RESPONSE TO REVIEWER COMMENTS

To: Grace Manahan
City Planner, Mercer Island

RE: 2306-124 SUB1 PLANS
Hong + Kao Residence

SF	MERCER ISLAND COVER SHEET
1.0	SITE PLAN
0.0	SITE SURVEY
C-1	CSWPP PLAN
C-2	DRAINAGE PLAN
0-3	DETAILS
2.0	LOWER FLOOR DEMOLITION PLAN
2.1	MAIN FLOOR DEMOLITION PLAN

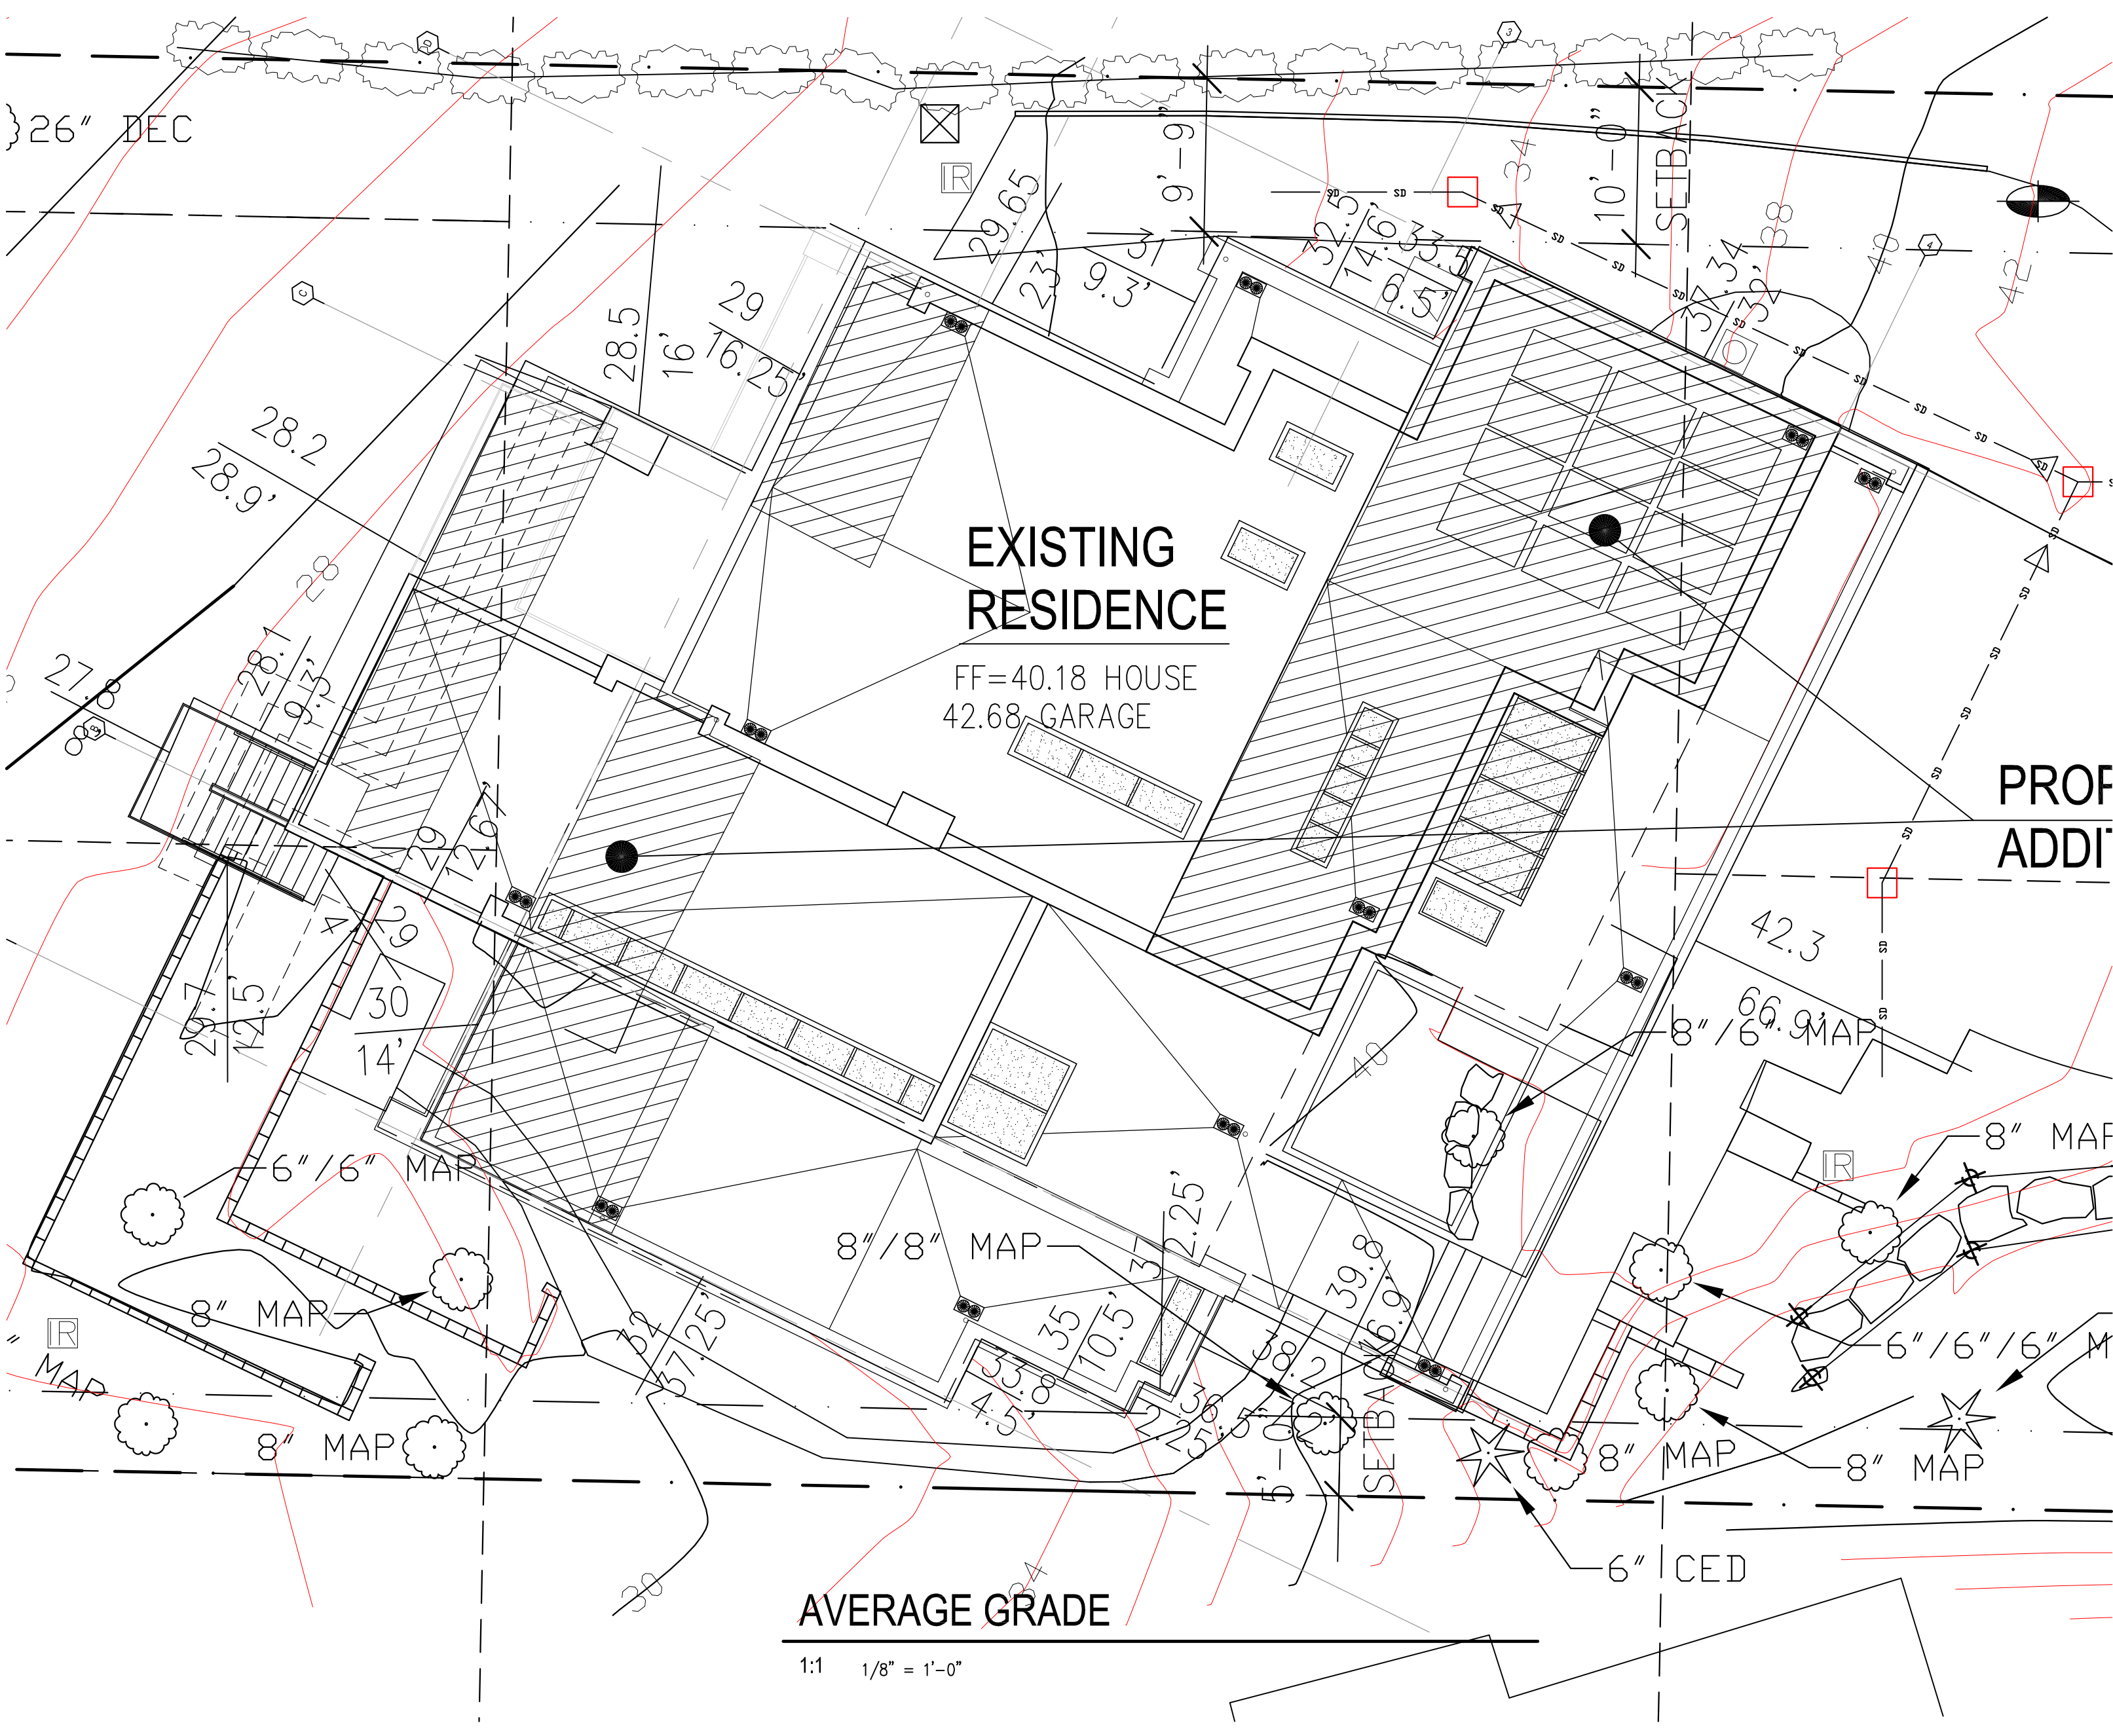
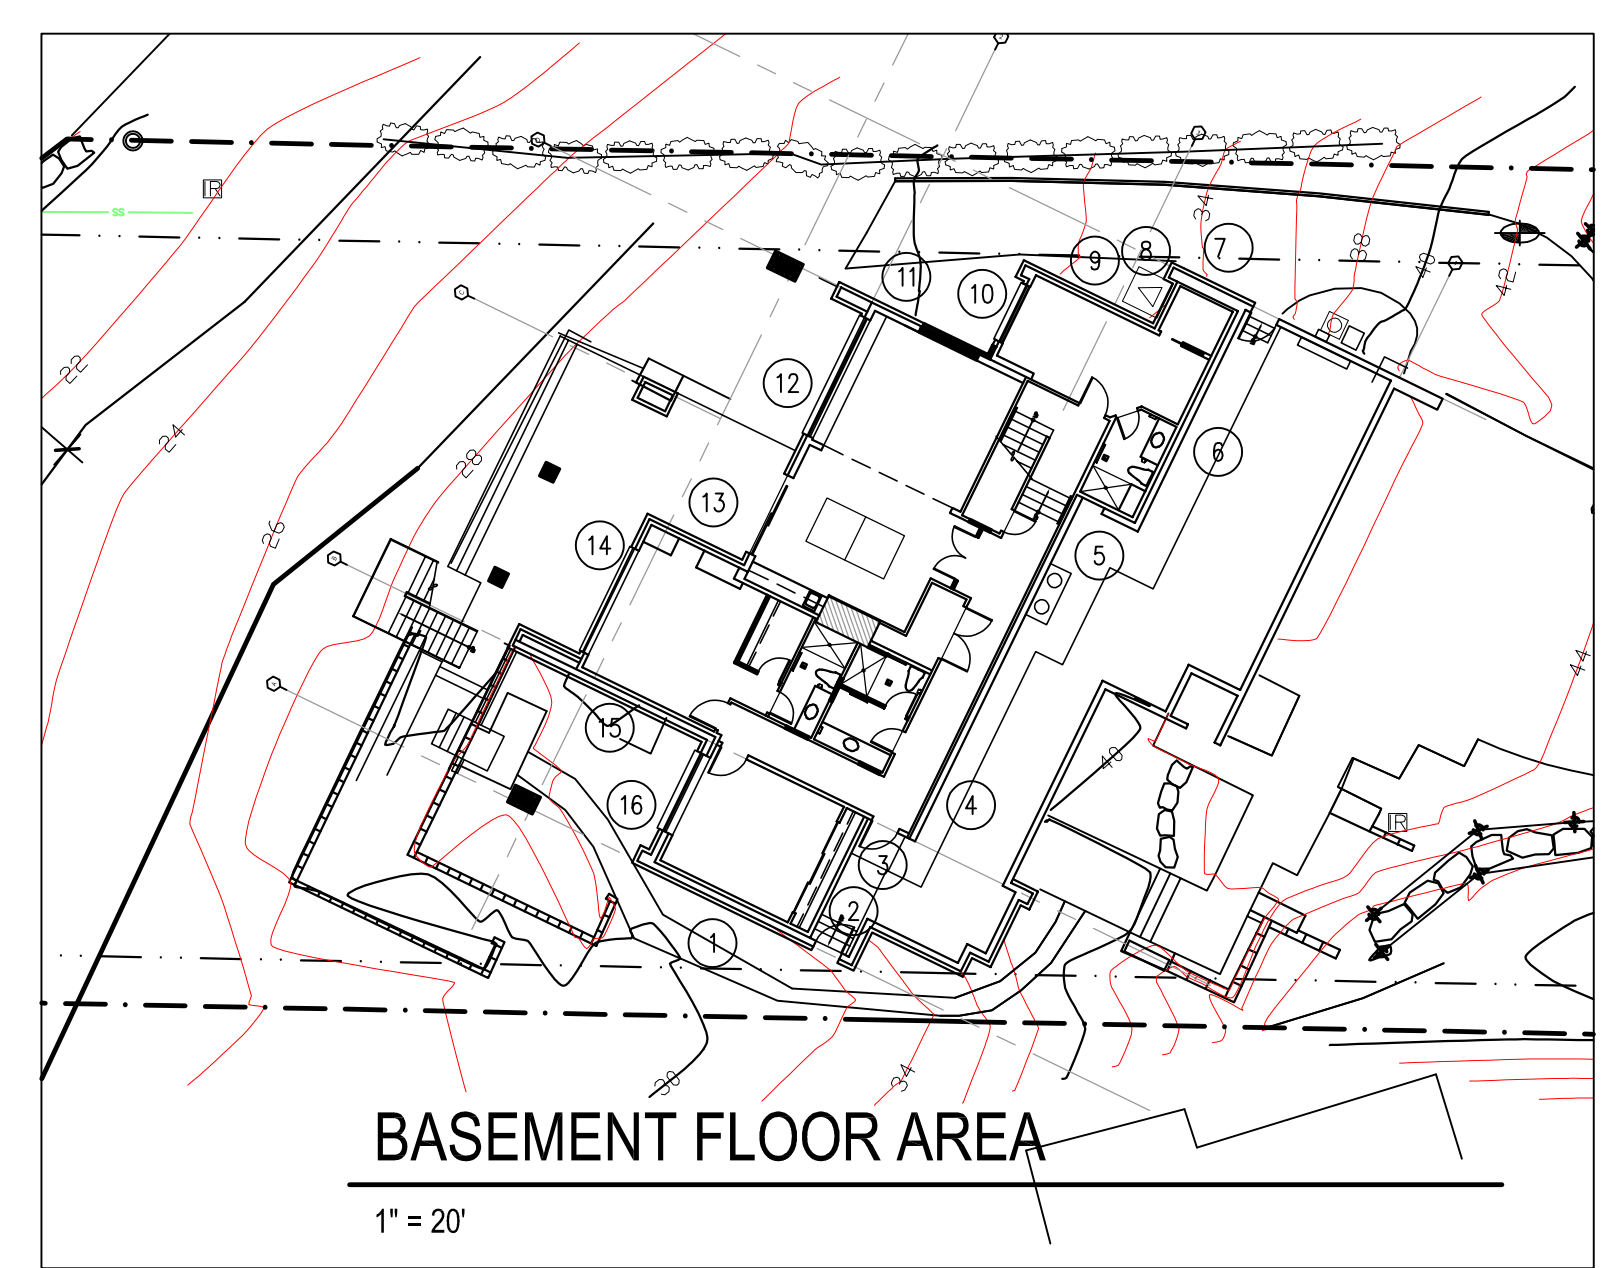
3. Documentation attached showing that structural changes to exterior walls are less than 40% of existing.
4. Revised south setback to 7'-6"
5. Geotech
6. Hardscape calculation are on Sheet 1.0 under LOT COVERAGE
7. Fire alternate request is attached.
8. Revised dimension on 5.0, structure is existing nonconforming and the height is not being increased on the downhill side. The addition is the same height as the existing.
9. Finish grades are shown on 1.0.
10. ABE and max height shown on all elevations.
11. geotechnical
